Access Report

**Proposed Education
Establishment**
57 Carrington Street
WEST WALLSEND NSW

For: Allambi Care
Ref: LP_21212

SK-1101

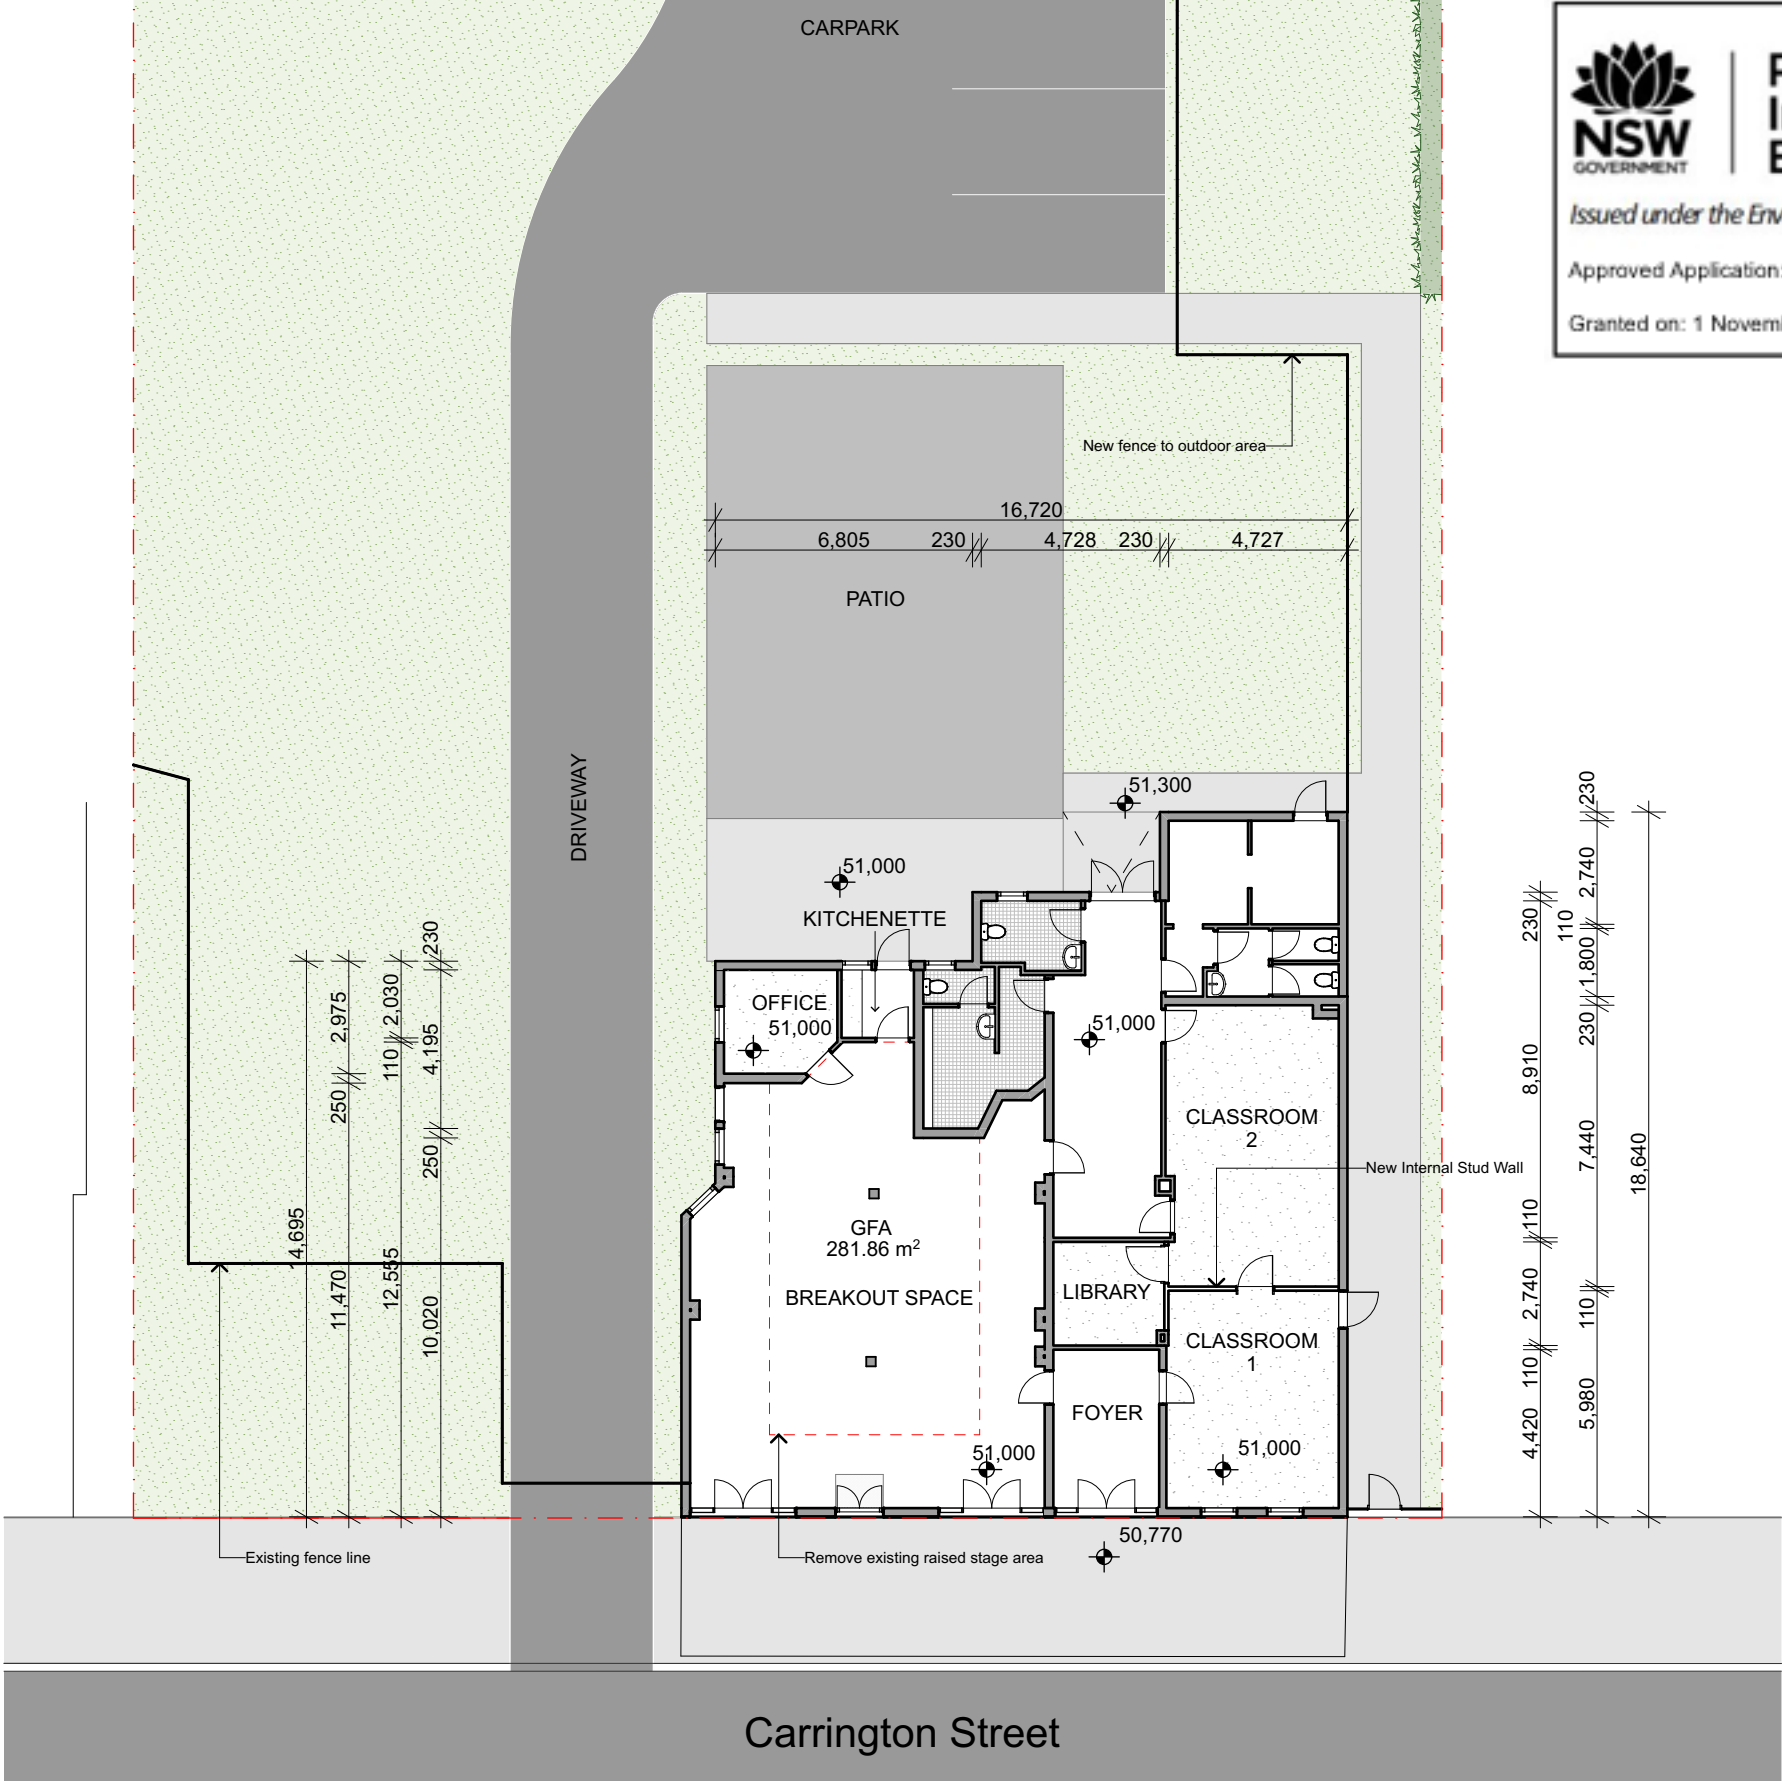
A new doorway will be provided within the partition wall being constructed to create Classroom 1 and Classroom 2, AS1428.1 has requirements for doorways within the accessible path of travel to enable independent access for people using a wheelchair and will be applicable to this doorway.

Adequate circulation areas are provided at the new doorway.

- a. Doorways within the accessible path of travel to have a minimum clear opening width of 850mm (AS1428.1(2009), Clause 13.2). We recommend the use of a 920 leaf door as a minimum to achieve adequate clear width.

- b. All doorways within the accessible path of travel to have complying circulation areas as illustrated in AS1428.1(2009), Figure 31. Circulation areas to have a maximum crossfall of 1:40.

- c. Doorways to have minimum 30% luminance contrast as described in AS1428.1(2009), Clause 13.1.
- d. Door to have hardware within the accessible height range of 900-1100mm above the finished floor level (AS1428.1(2009), Clause 13.5)

- e. Door handles and related hardware shall be able to be unlocked and opened with one hand per AS1428.1 (2009), Clause 13.5.1. The handles shall enable a person who cannot grip to operate the door without their hand slipping from the handle. We recommend the use of lever handles.

- f. Doorways to external areas to achieve a level threshold as part of the accessible path of travel. Maximum allowable construction tolerance is 3mm for compliance with AS1428.1(2009), 5mm where beveled edges are provided between surfaces.

- g. Doorways to have operational forces per AS1428.1 (2009), Clause 13.5.2. A maximum allowable force of 20N is required to operate the door.
